Harnett County Government Complex
307 Cornelius Harnett Boulevard
Lillington, NC 27546

October 7, 2005

**Re: Status of Improvement Permit Application #05-5-13078R
Lot 17 Cherokee Ridge**

CHEROKEE RIDGE SUBDIVISION
PHASE ONE

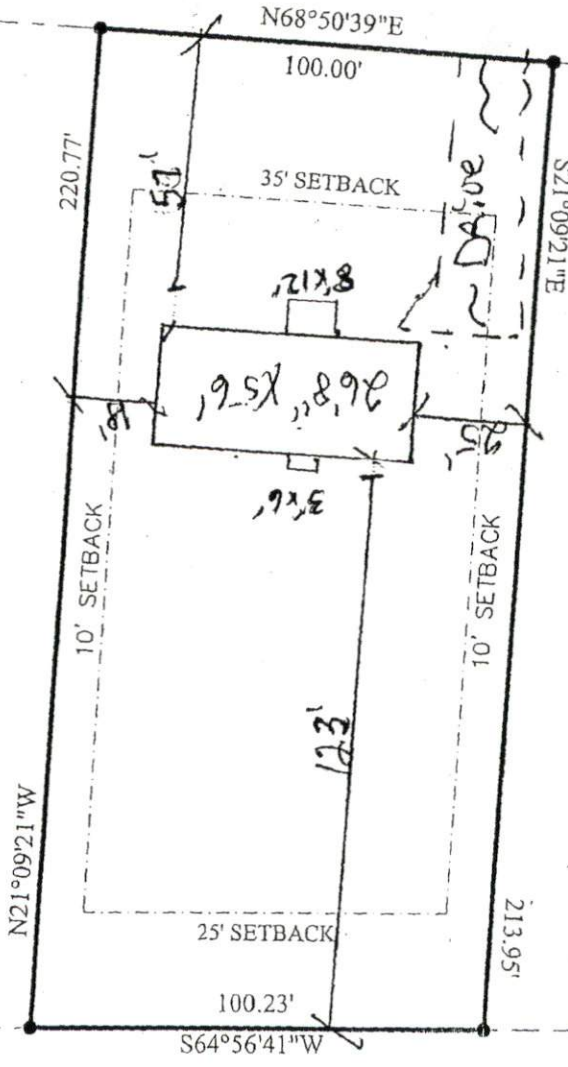
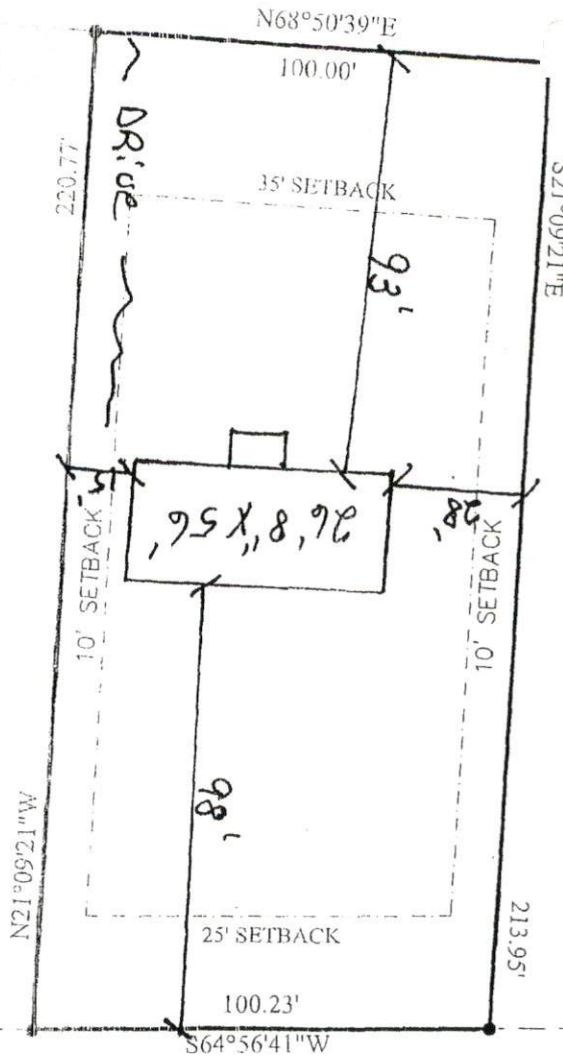
- 1. Property lines/corners not marked or labeled
- 2. House corners not marked or labeled
- 3. Directions not clear to property
- 4. Property needs brush or vegetation removed
- 5. Backhoe pits required
- 6. Other **Please note required changes in house location. Please submit new plot plan to Central Permitting.**
